Subject: RE: Y/9818/RES and Y/97/18/DOC

Laura Gibbons, MEng, GMICE
Engineer (Drainage & Coastal)

Job Title			
LAND SOUTH OF BURNDILL ROAD, YAPTON			
Drawing Title			
PRELIMINARY ENGINEERING LAYOUT			
Client			
BOVIS HOMES			
Scale	Date	Designed	SG
1:500 @A1	NOV 18		
Drawn	Checked	Approved	RS
SOM	LH		
Job No	Drawing No		Rev
18-070	18-070/103		P

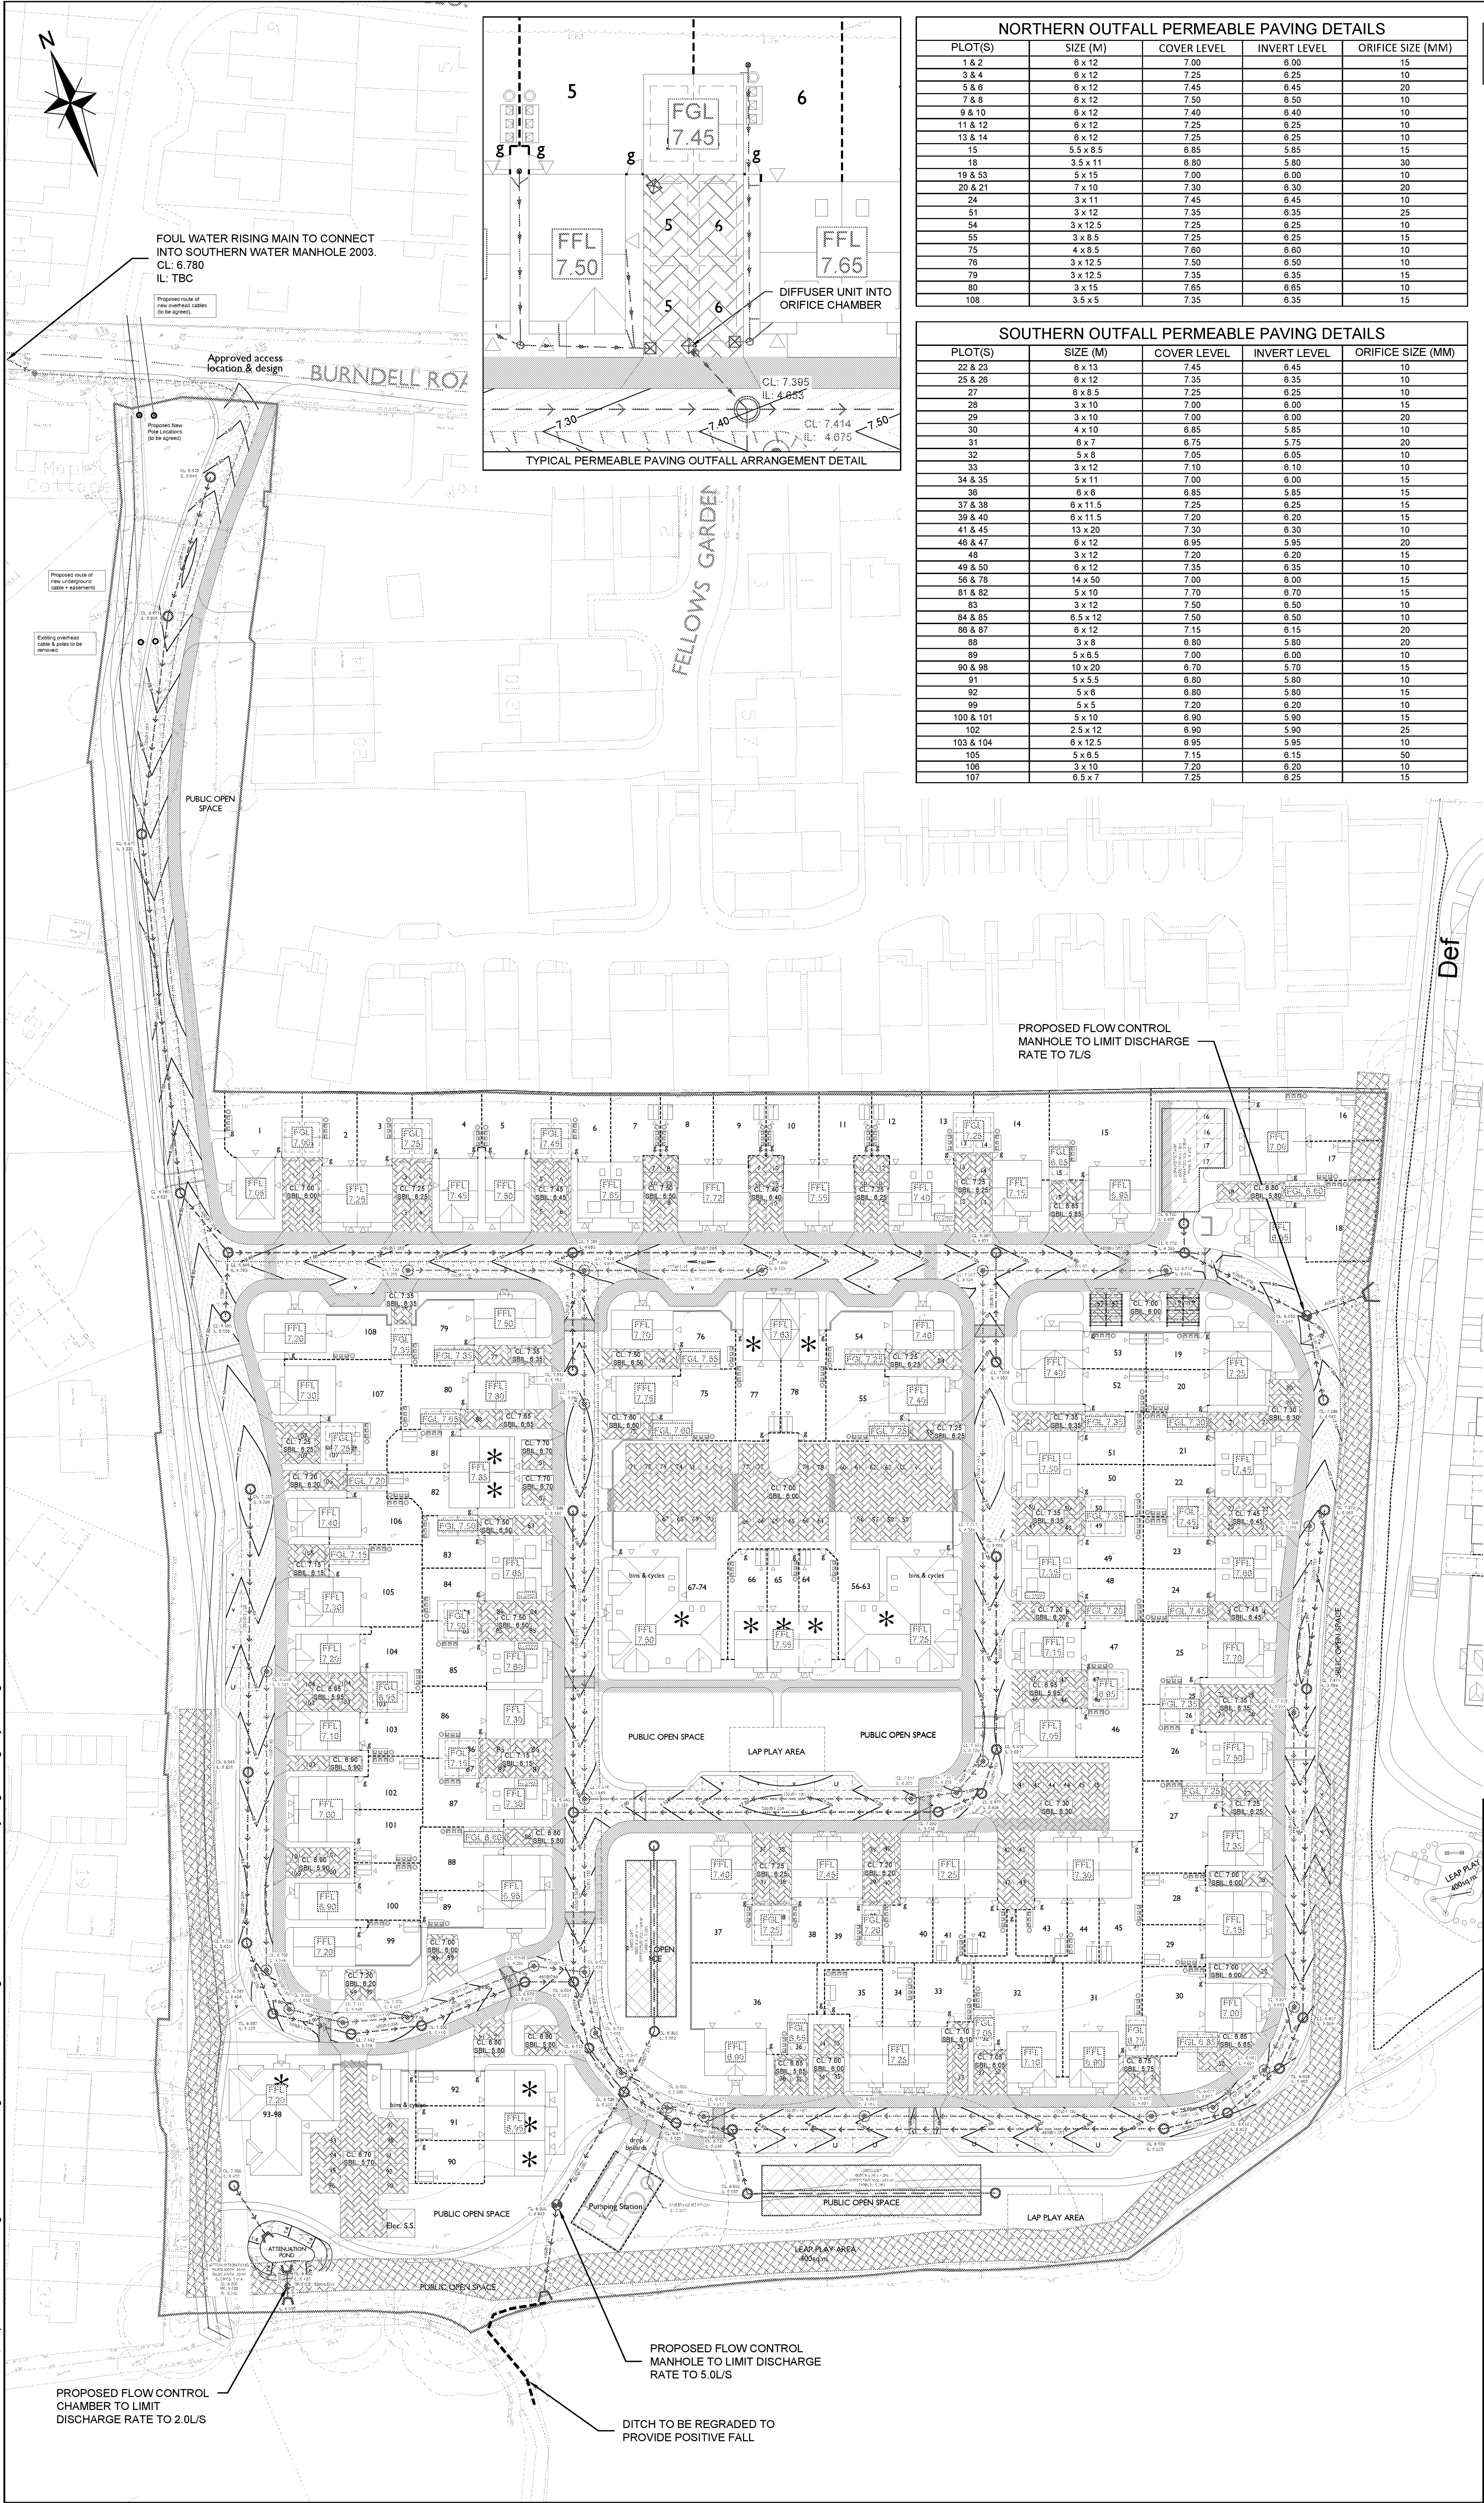
6. Please provide a schedule of permeable paving subbase depths and orifice diameters.
7. Please provide finish and formation levels of permeable paving on plan.

9. There appear to be some discrepancies between tank dimensions (area and invert levels) shown on plan and those in calculations. Please check and update.
